Please ask for: Nicola Moore
Email: nicola.moore@arun.gov.uk
Telephone: Ext 37944
Our Ref: Y/150/21/HH
Your Ref:
Date: 3rd November 2021

Application for Planning Permission for Works or Extension to a Dwelling

Development: Detached single storey home office/garden building in rear garden.
Location: 15 Kings Close Yapton BN18 0EX

Block Plan shows area bounded by: 497891.95, 103025.92 497981.95, 103115.92 (at a scale of 1:500), OSGridRef: SU9793 307. The representation of a road, track or path is no evidence of a right of way. The representation of features as lines is no evidence of a property boundary.

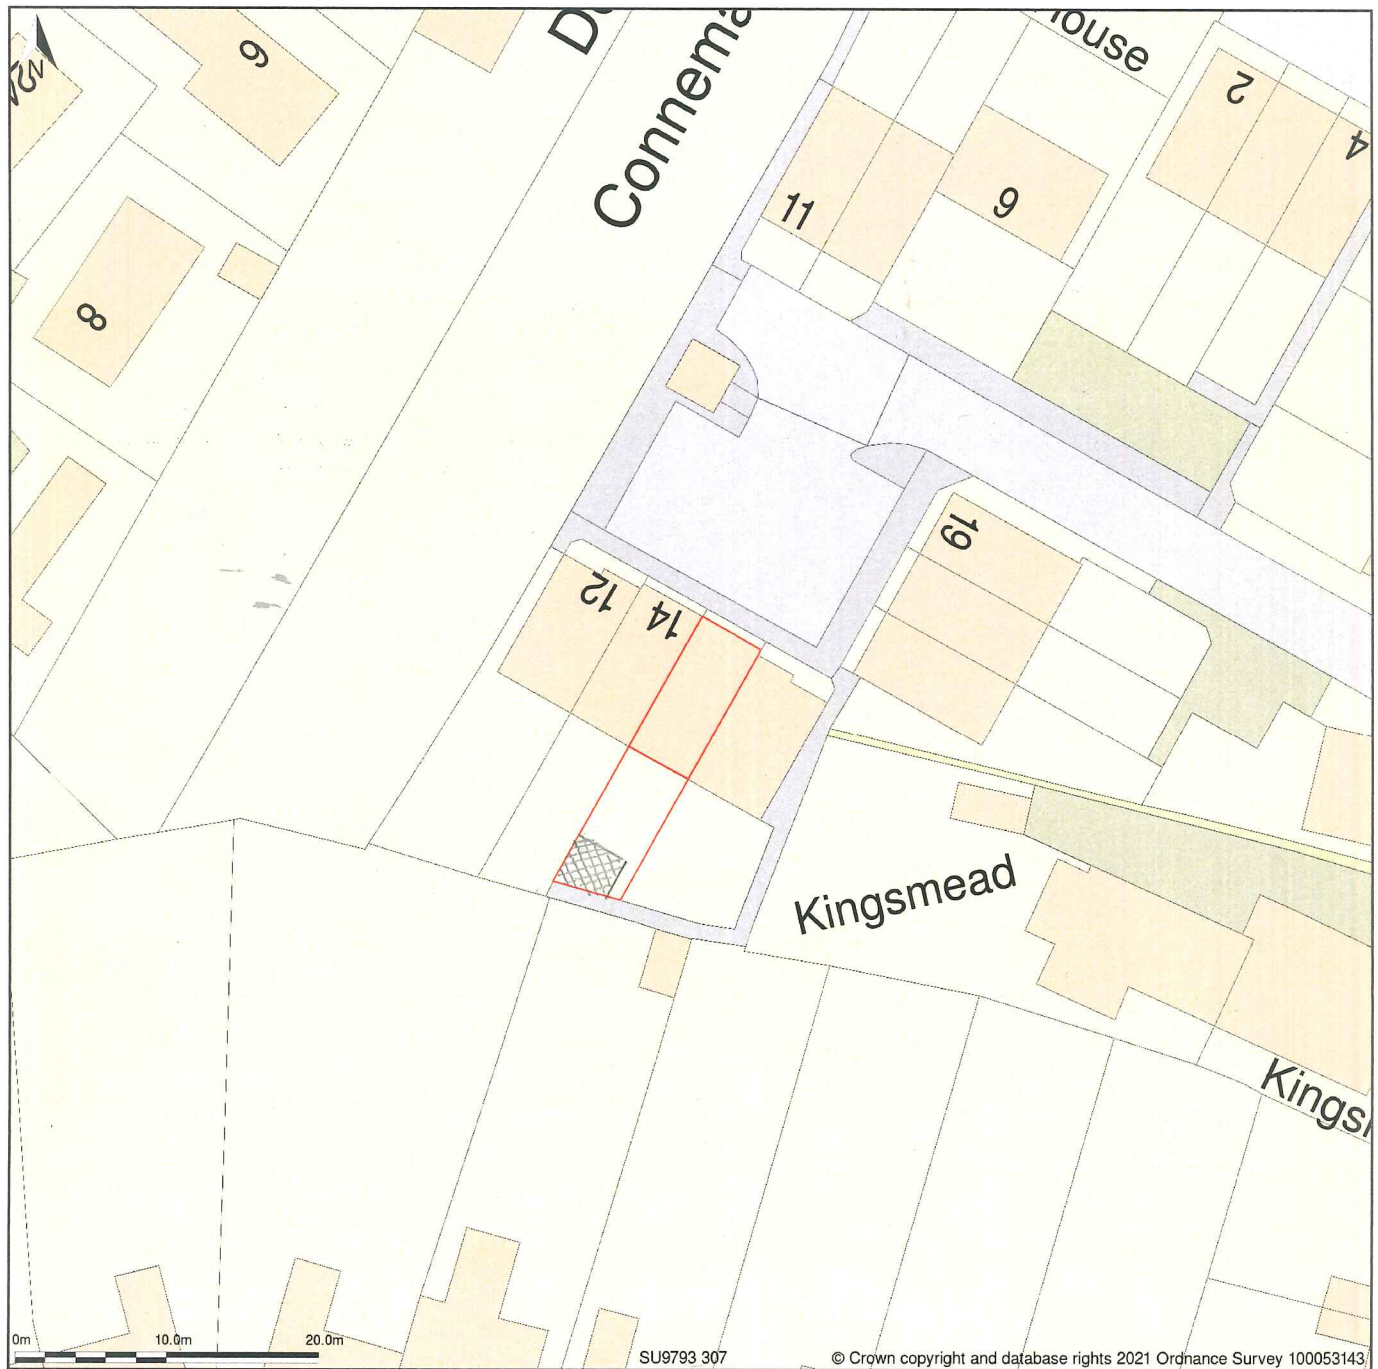
Block Plan

The Block Plan should clearly show the proposed development (this can be hatched or highlighted). Please amend accordingly and re submit. Further details of what must be included on the plan can be found in the Validation Requirements List.
